Morgan and Morecambe Offshore Wind Farm: Transmission Assets

Appendix G6 to Natural England's Deadline 6 Submission
Natural England's comments on Onshore Ecology

Planning Inspectorate Reference EN020028

Morgan and Morecambe Transmission Assets G6 – Comments on Onshore Ecology and Nature Conservation

**Figure 1.3: NVC digitisation of Fylde sand dunes (from Skelcher (2016))**

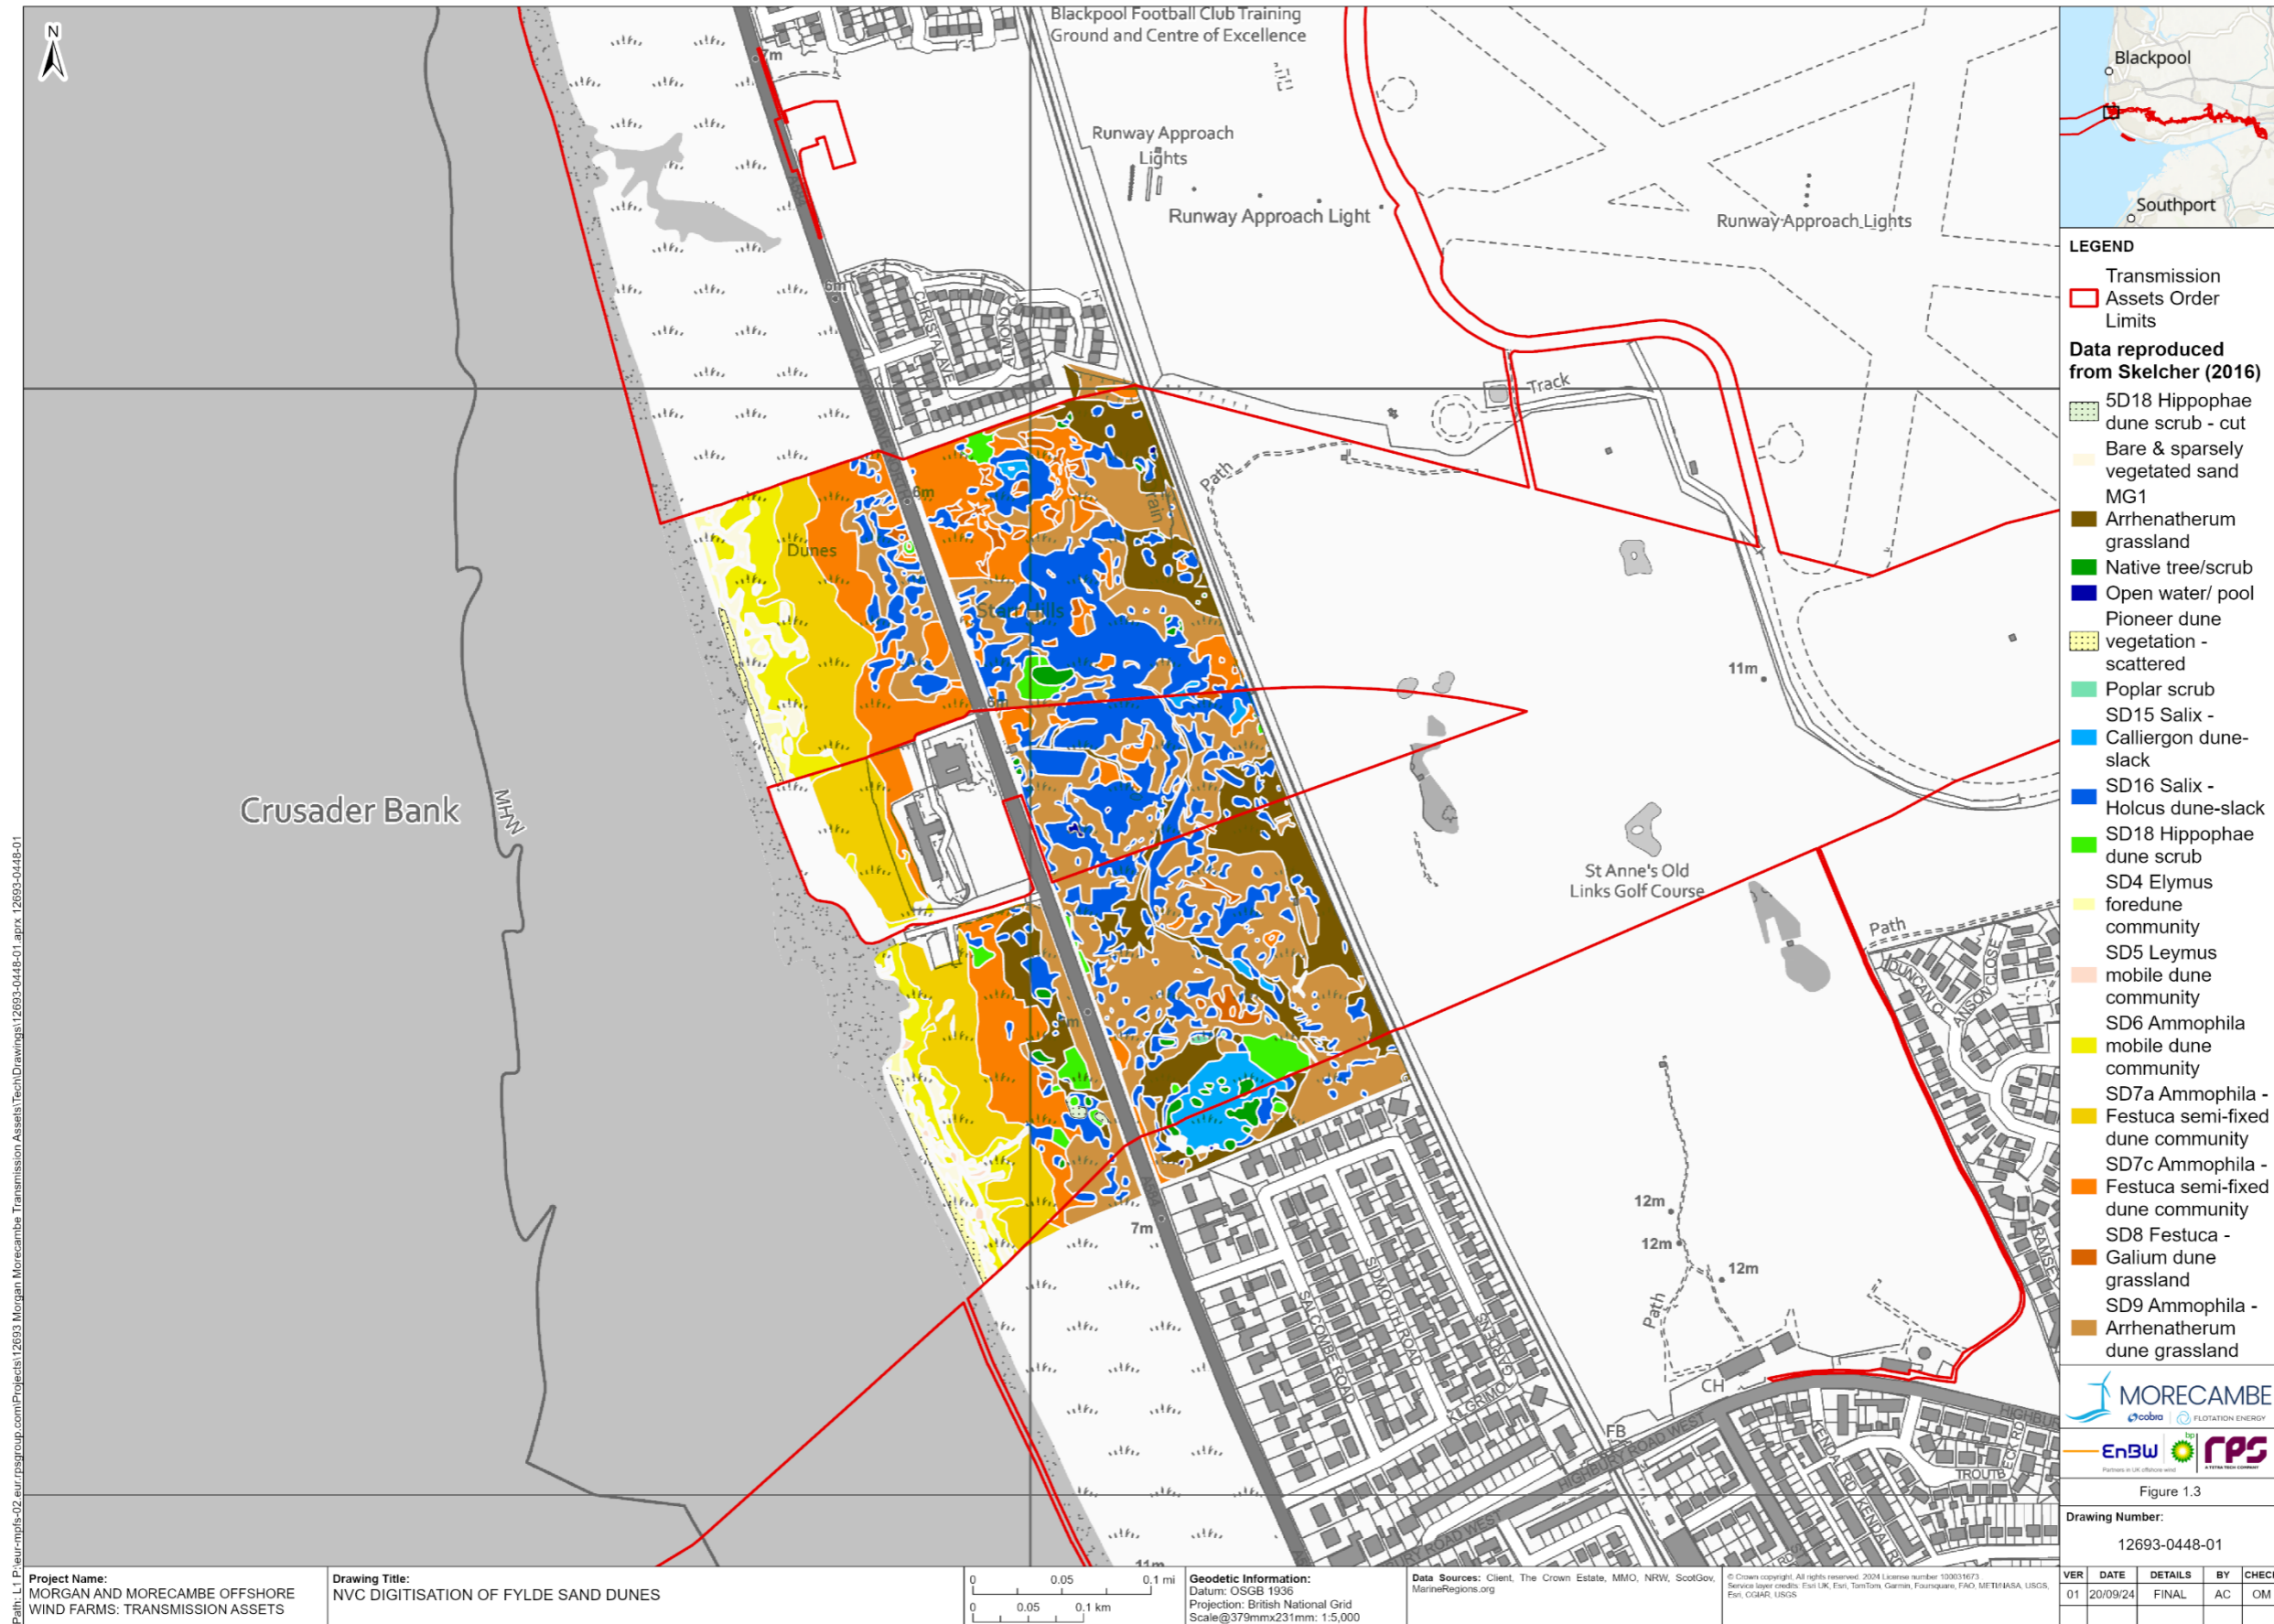
The NVC survey map (Figure 1.3) of Lytham St Annes Dunes SSSI (Appendix D) [REP5-039] shows a blue dashed line with the approximated dune extent. This extends beyond the Lytham St Annes Dunes SSSI boundary (and into the Ribble Estuary SSSI boundary) and supports transitional embryonic dune habitat along with SD4 *Elymus farctus* ssp. *boreali-atlanticus* foredune community, SD5 *Leymus arenarius* mobile dune community and SD6 *Ammophila arenaria* mobile dune community. We advise the Applicant to confirm the distance of dune growth in meters from the edge of Lytham St Annes Dunes SSSI to confirm the extent of the frontal dunes and if this has the potential to be impacted by construction works at landfall.

Gain), the Applicant should include detail on how the dunes will be protected during the works e.g. from access by construction workers. This should be included in the Landfall Construction Method Statement.
